Listed Building Consent for Alterations, Extension or Demolition of a Listed Building

Development: Listed building consent for the replacement of double glazed aluminum / timber windows and doors with double glazed painted timber casement, sprung sash windows and matching French doors.

Location: Little Welbourne Church Lane Pagham PO21 4NX

DRAWING TITLE
Proposed Window / Door Schedule

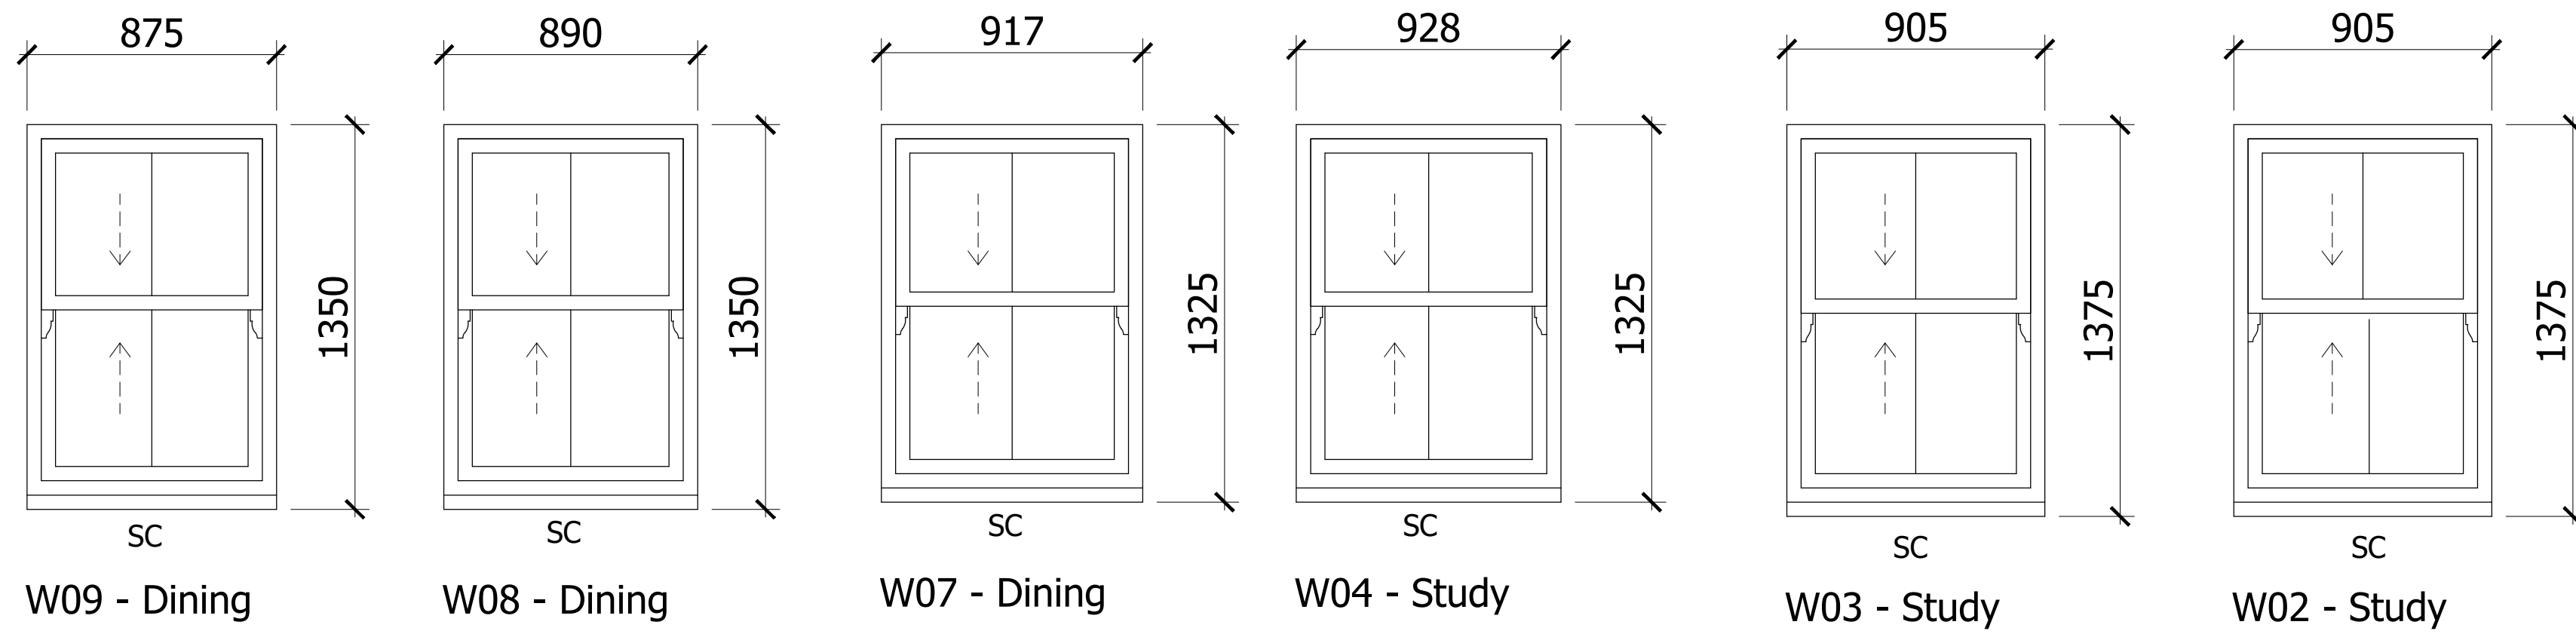
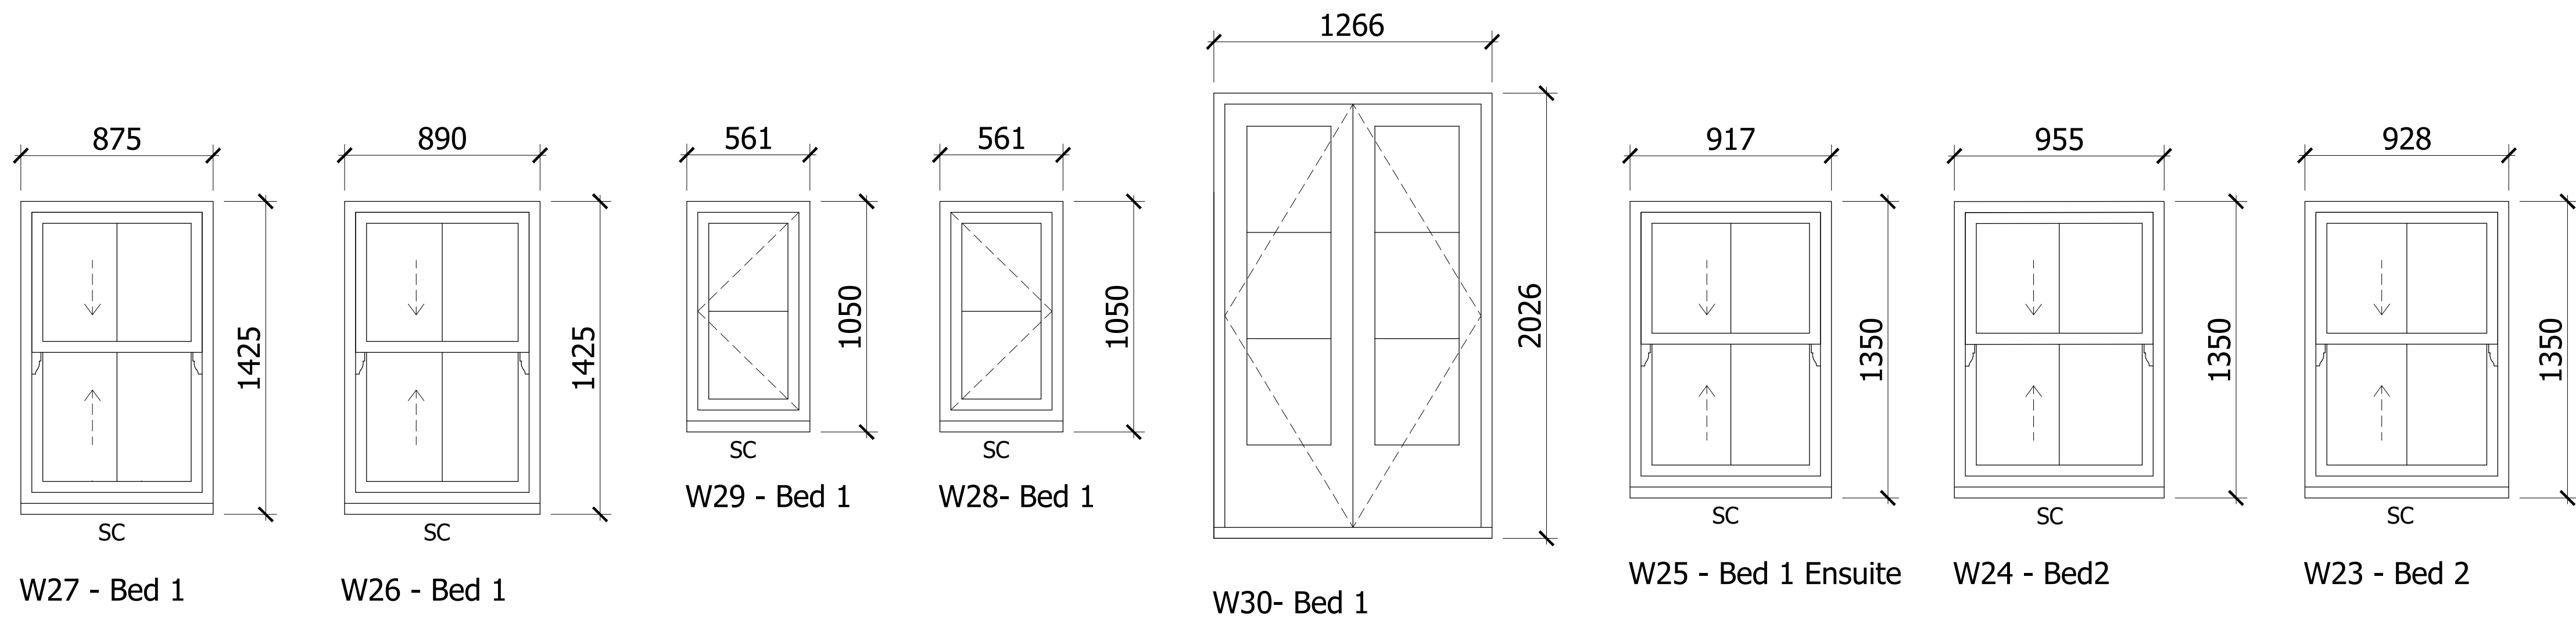
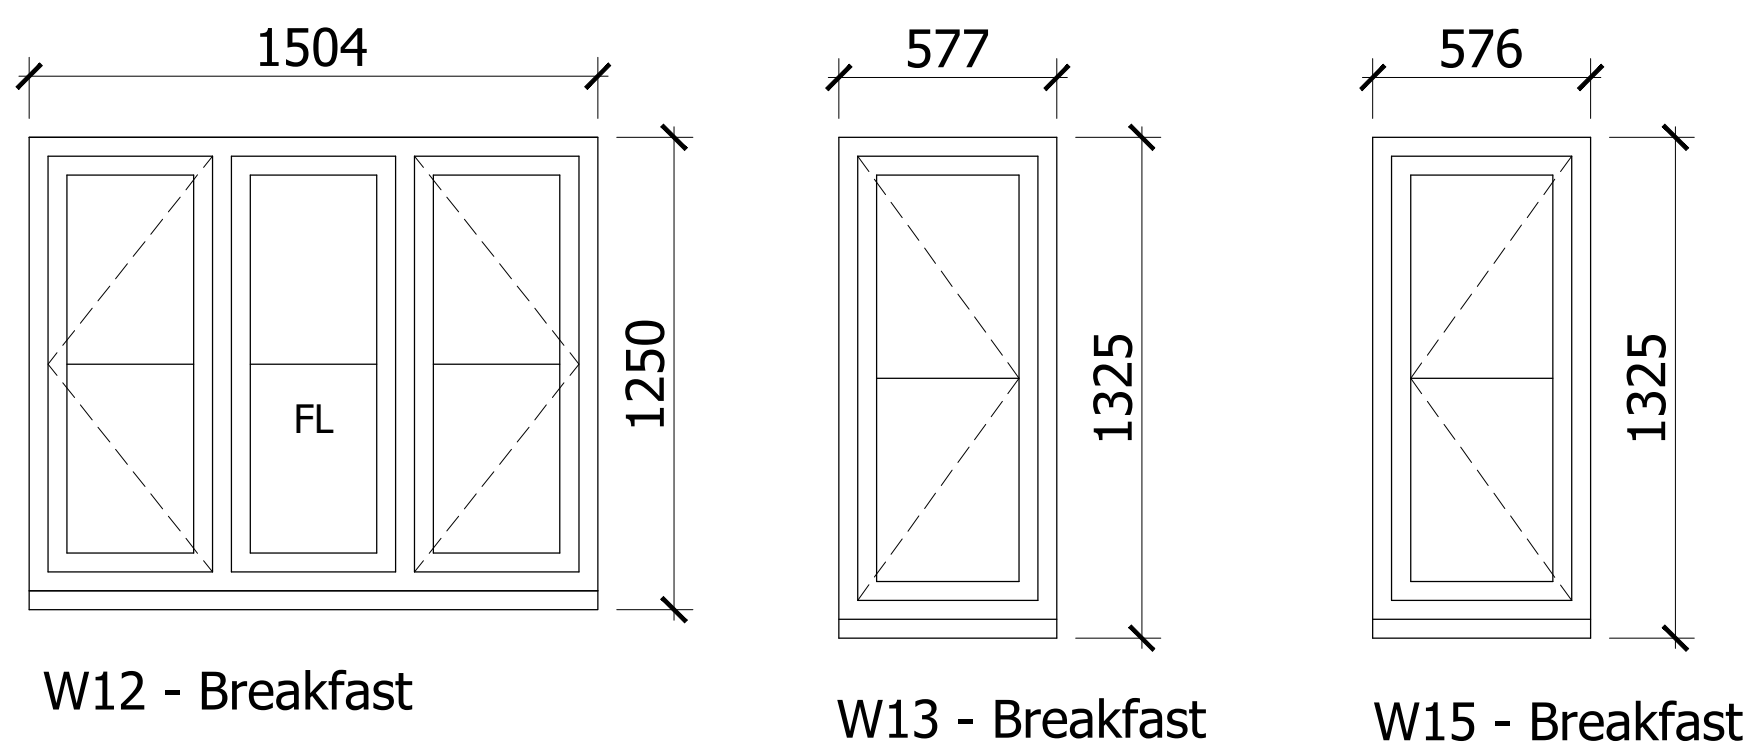
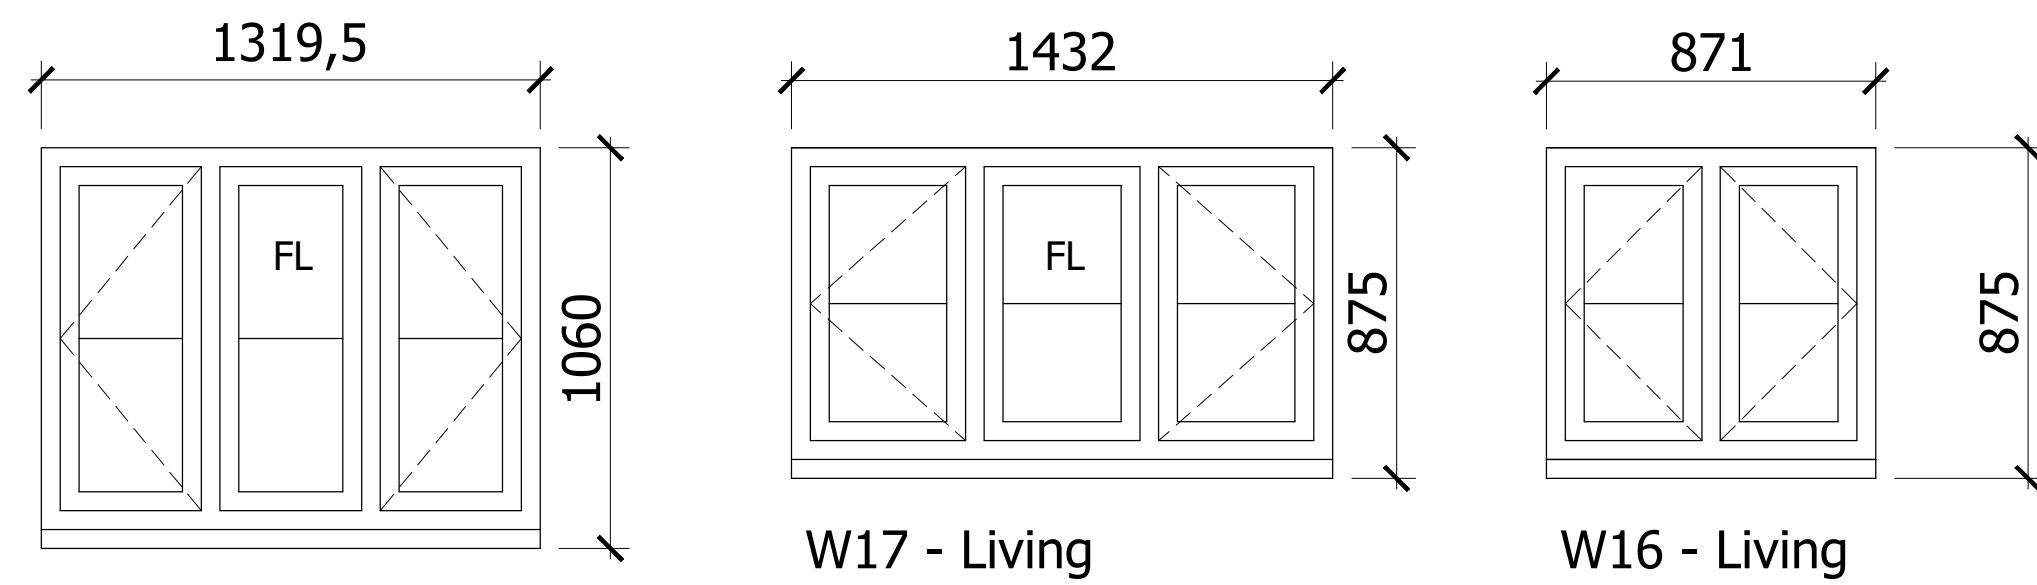
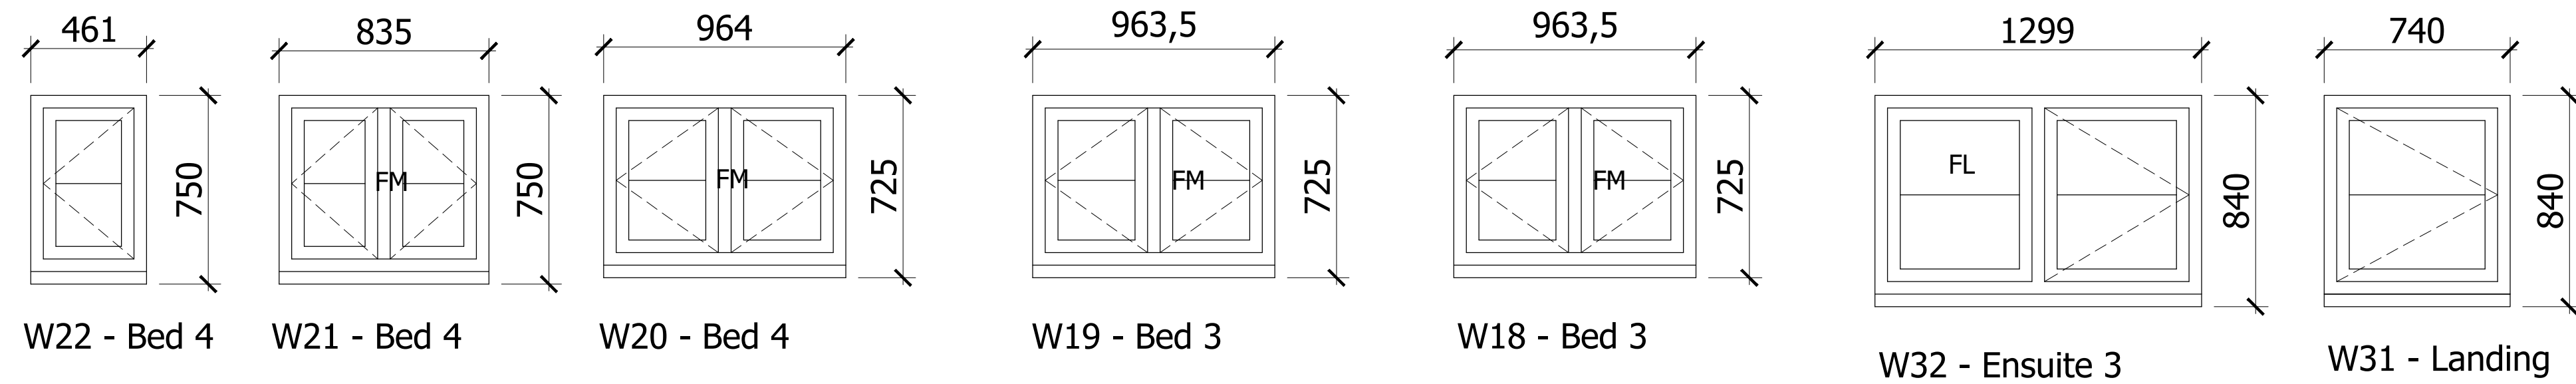
The proposed W10 north elevation door is drawn as a window on the proposed ground floor plan and isn't shown in the window/door schedule

The number of windows and external doors shown to be changed are inconsistent between the schedule and the elevations

NORTH ELEVATION

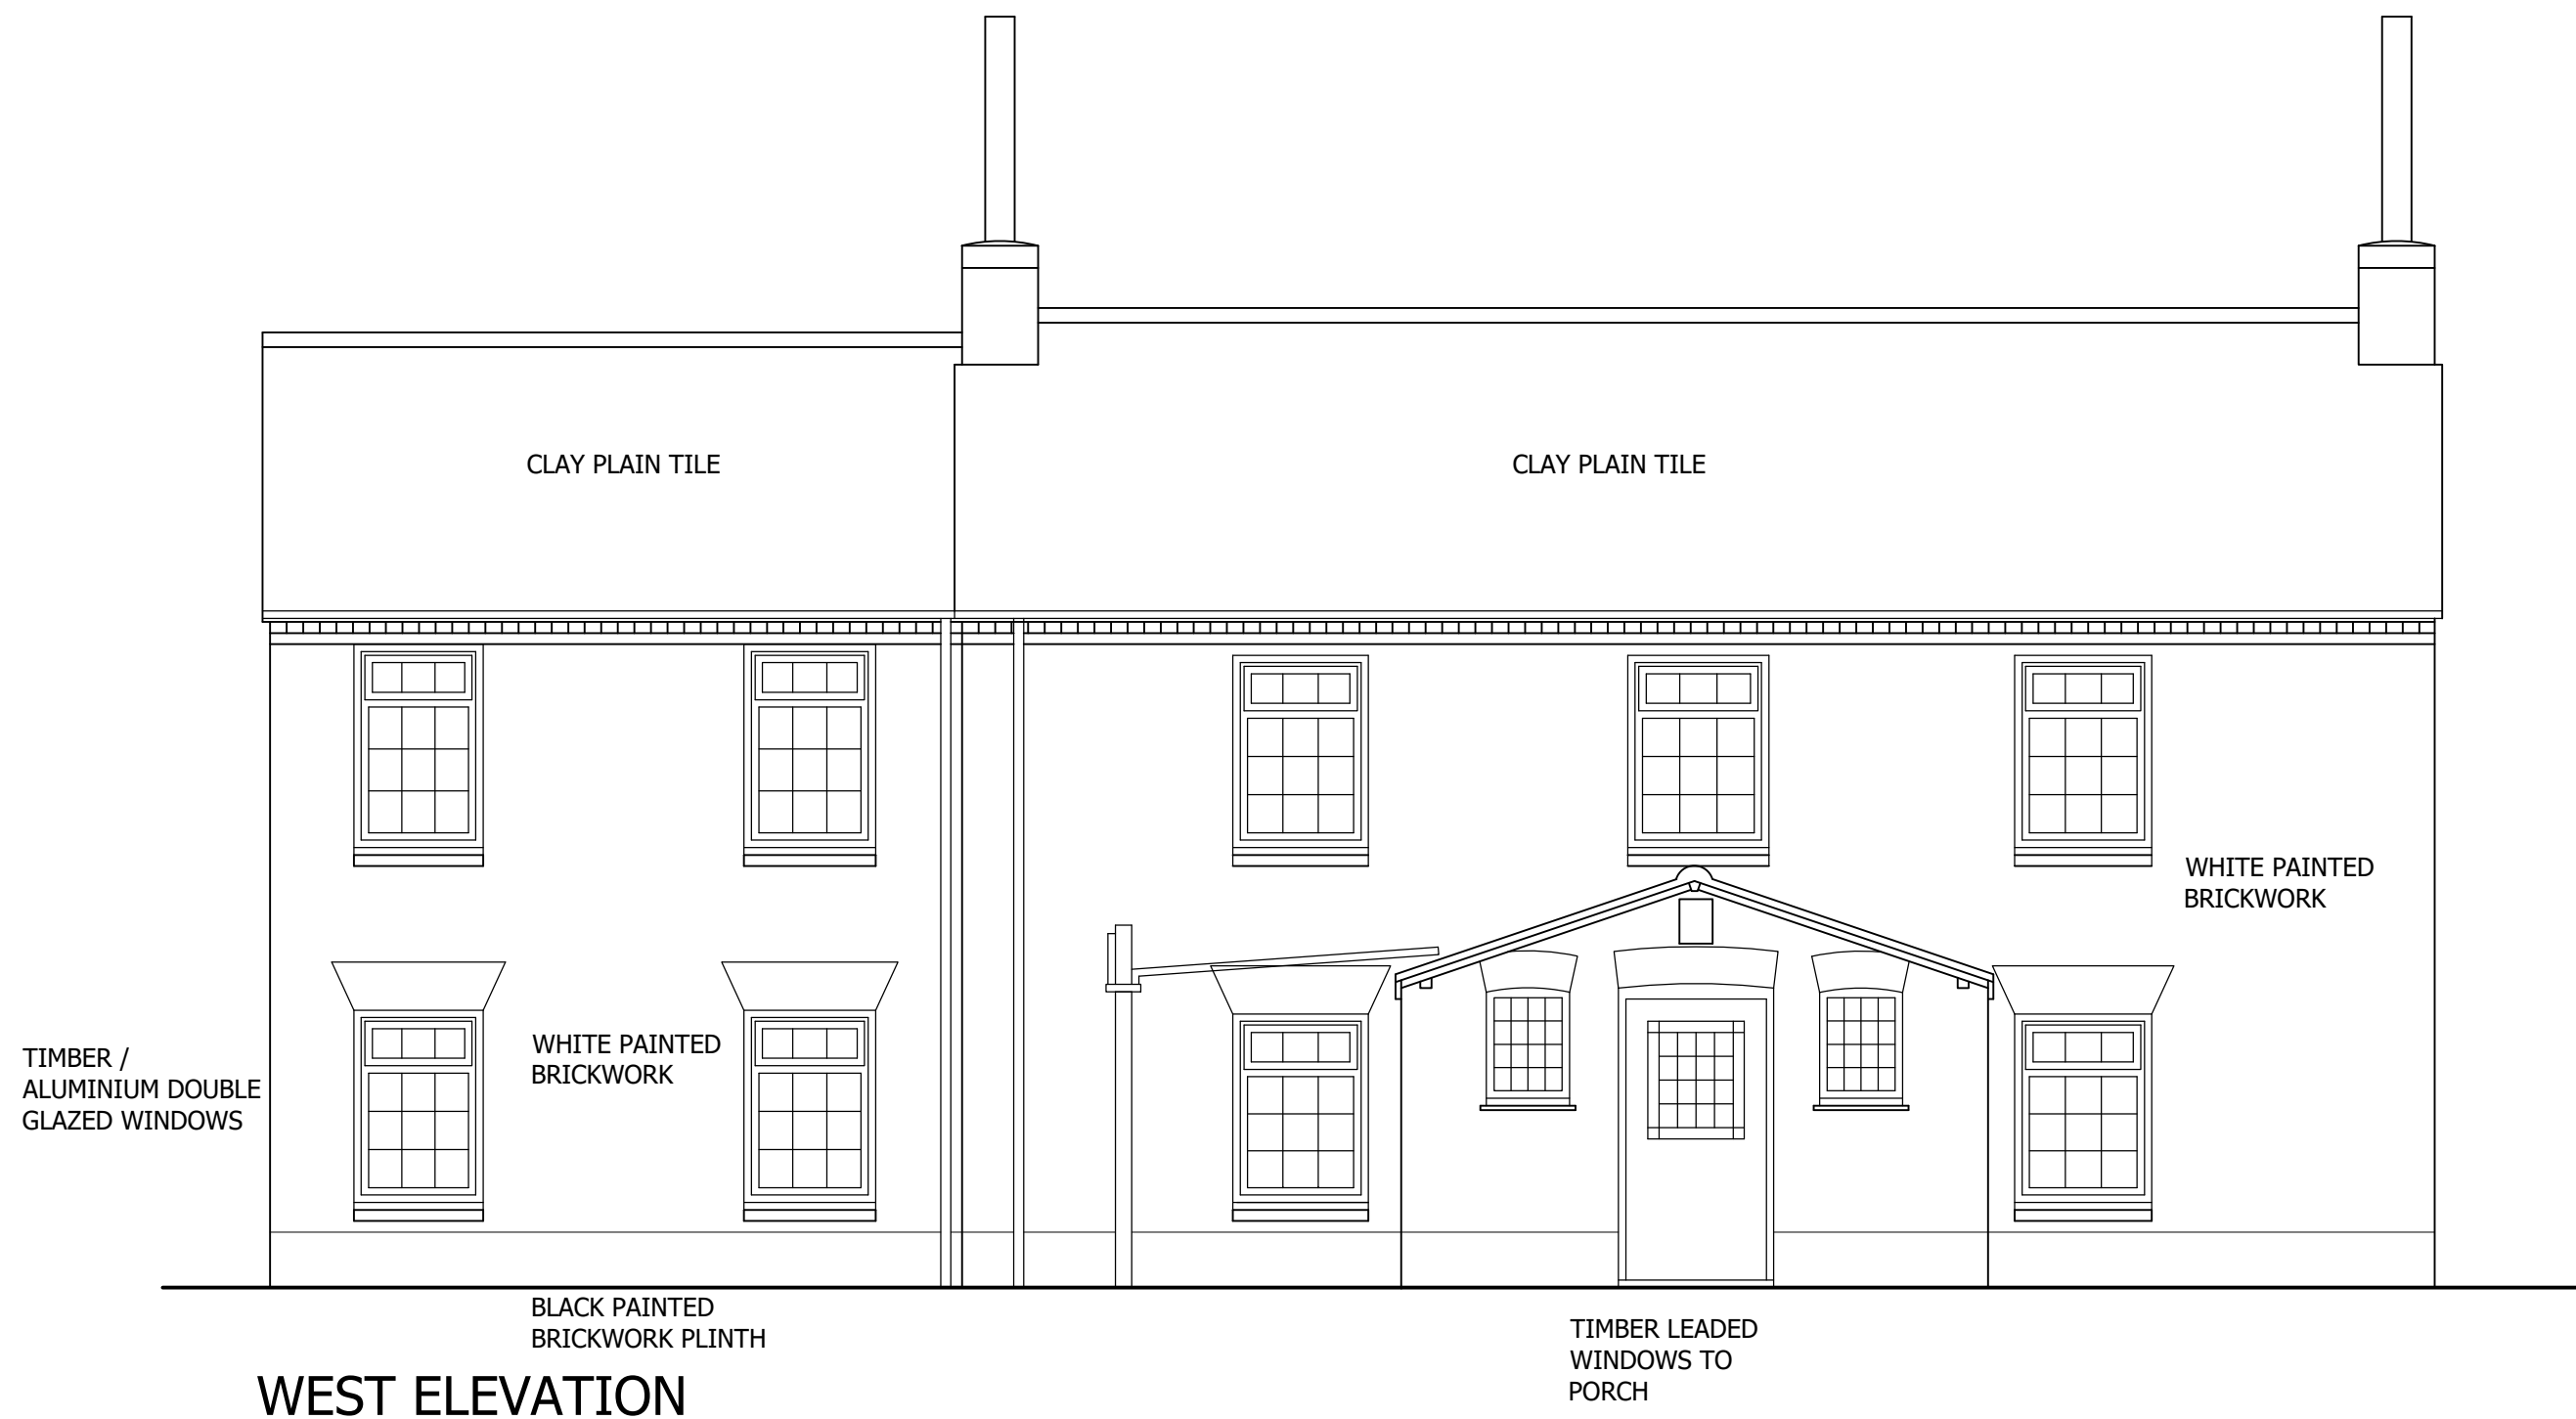
Part of the roofing on the proposed north elevation plan is inconsistent with the existing north elevation plan. Please clarify or amend. If changes to the roof are within the proposal then a roof plan will be required and works should be included in the application description.
